## REQUEST

Proposed Zoning: UR-2(CD) (urban residential, conditional)

The petition proposes to allow an infill residential development with 26 single family attached (townhome) units on vacant land north of the intersection of The Plaza and Milton Road.

RZ-1

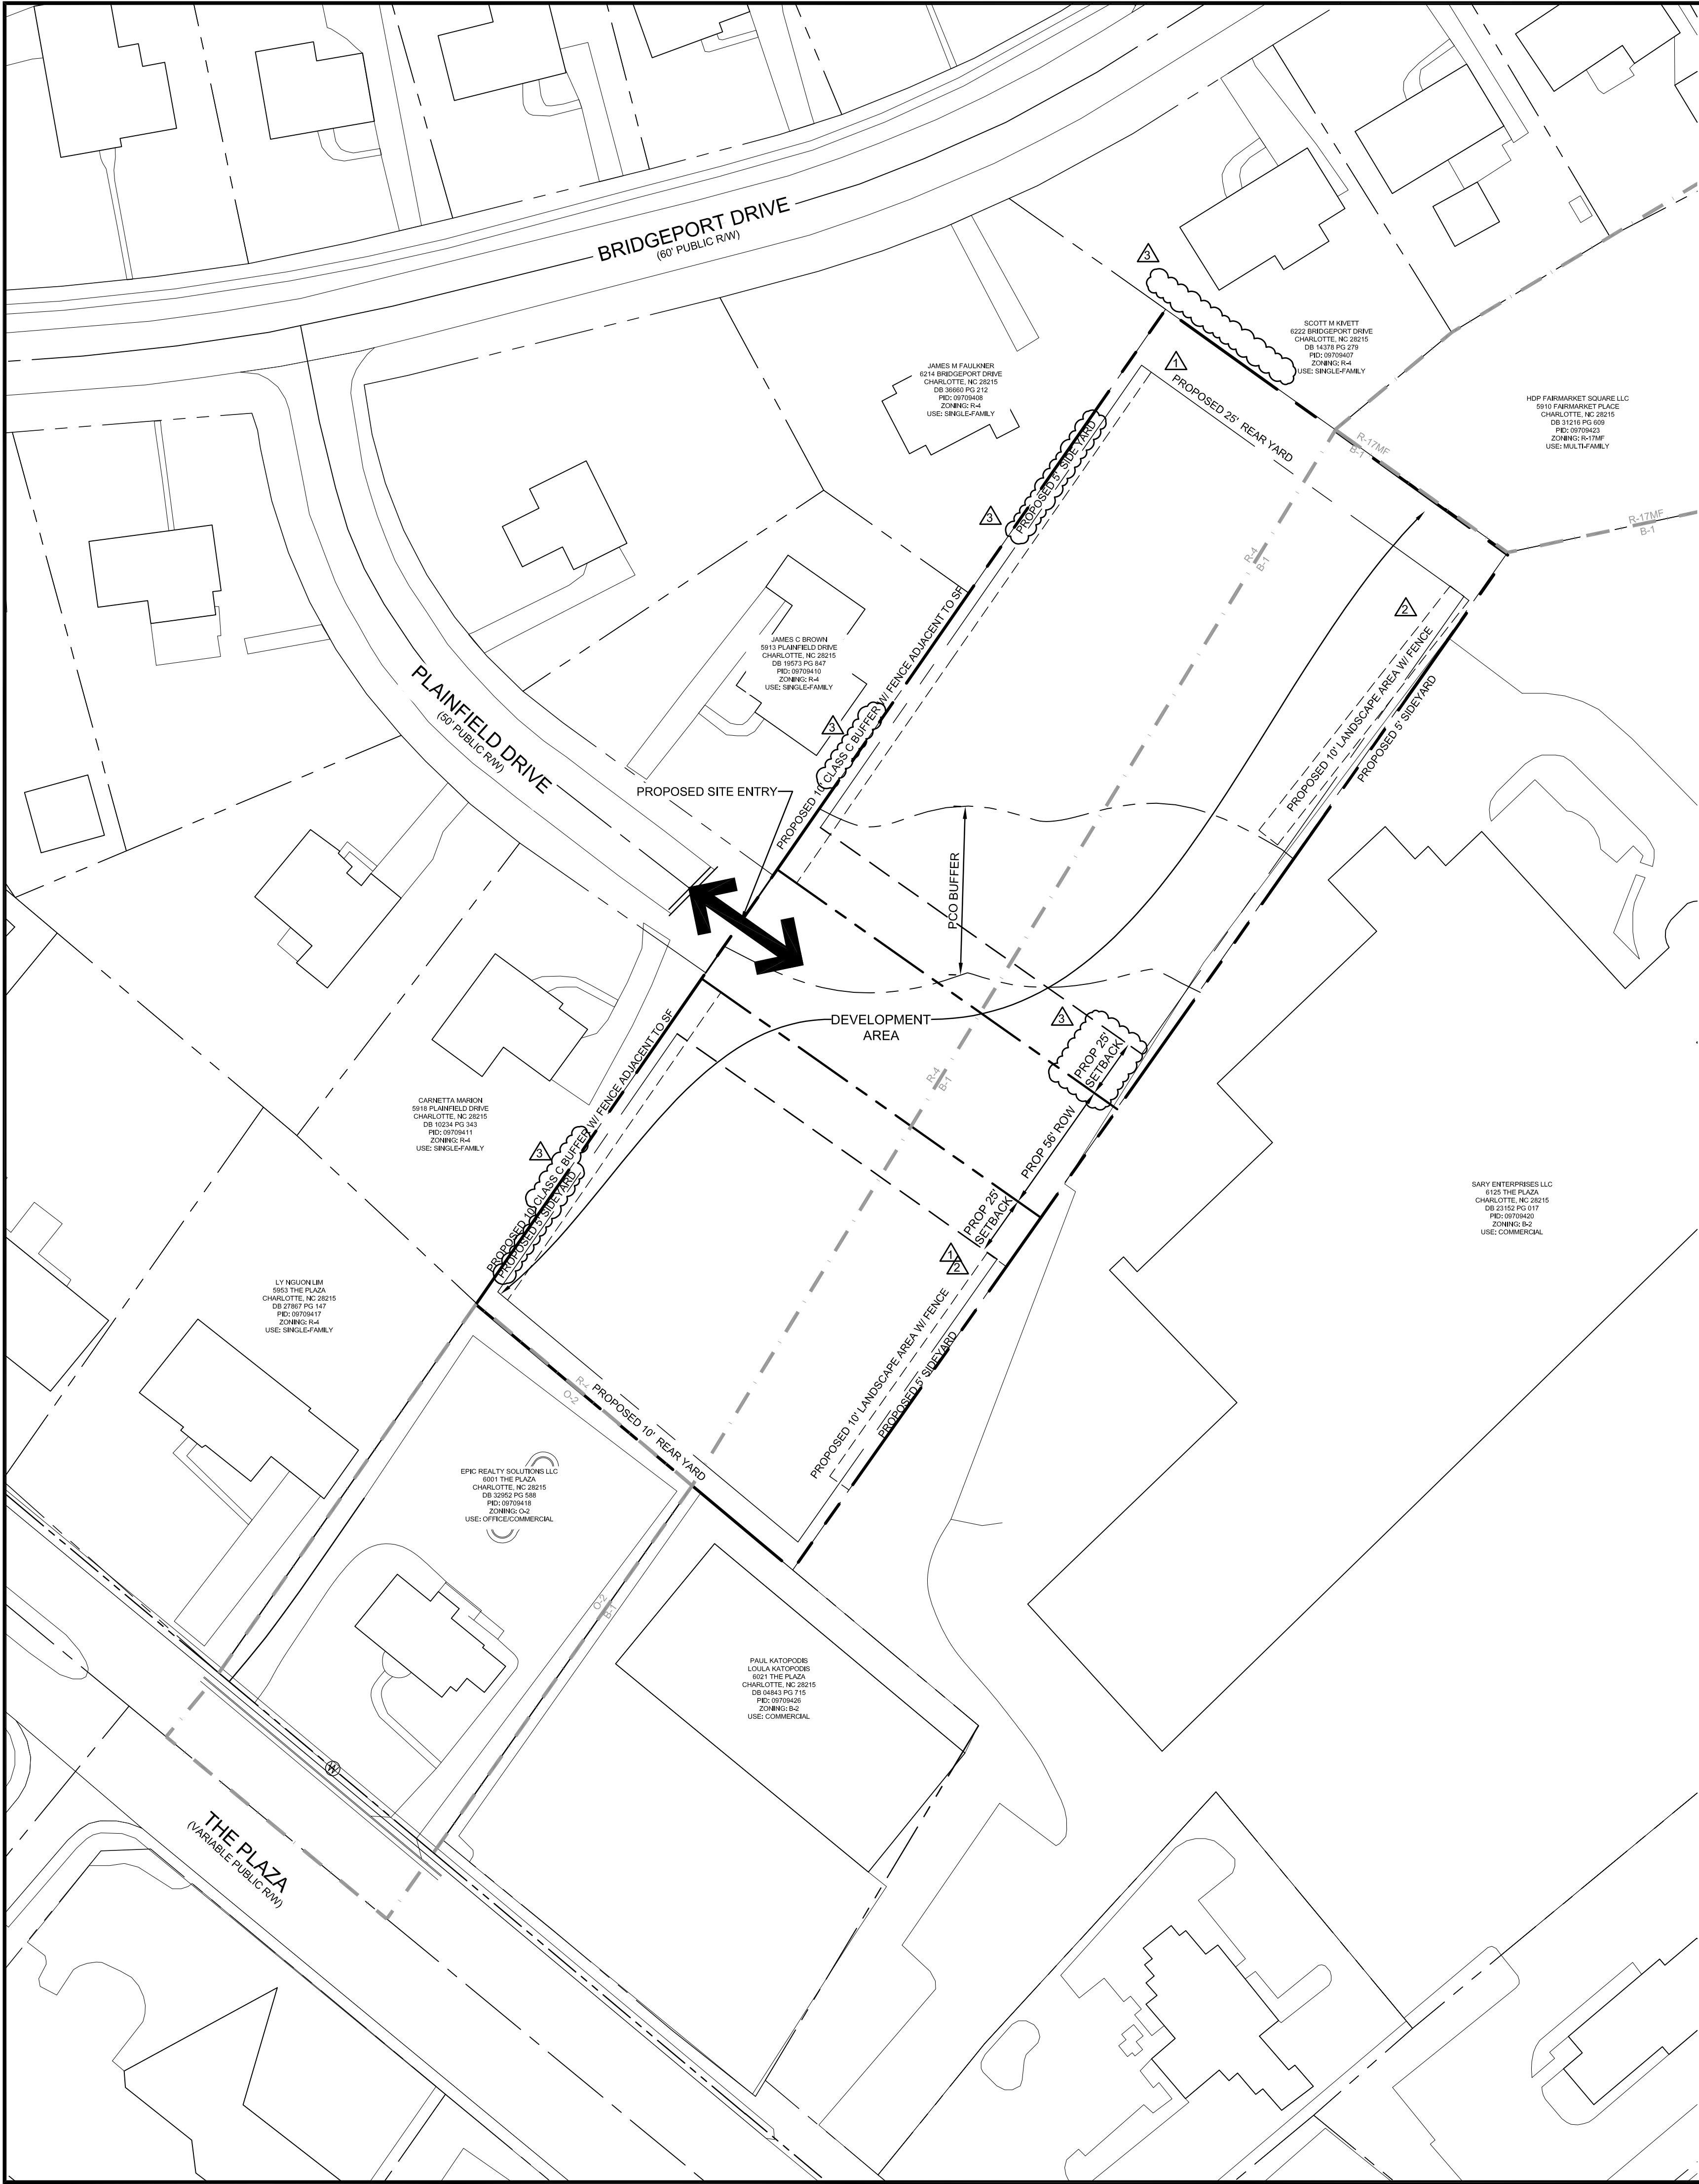
1. The proposed dwelling units exceeds 12 per acre. Per Chapter 20 Subdivision ordinance, site plan and conditional note(s) revisions are needed to commit to construct an 8-foot planting strip, and 8-foot sidewalk along all public roads. The wider sidewalk also meets the Charlotte WALKS Policy. Reference (CLDSM standard detail U-02) for residential medium street typical. Clarifying Comment 12-21-22: Petitioner should add conditional note stating commitment of 8' planting strip and 8' sidewalk along both sides of all public roads. Reference (CLDSM standard detail U-02) for residential medium street typical section. Potential environmental conflicts to be coordinated during permitting if full section cannot be achieved.

2. Ensure that tree save meets proper standards. Protected tree save should be roughly 30 feet wide. Any tree save not protected to meet the minimum requirements will need to be replanted at 150%
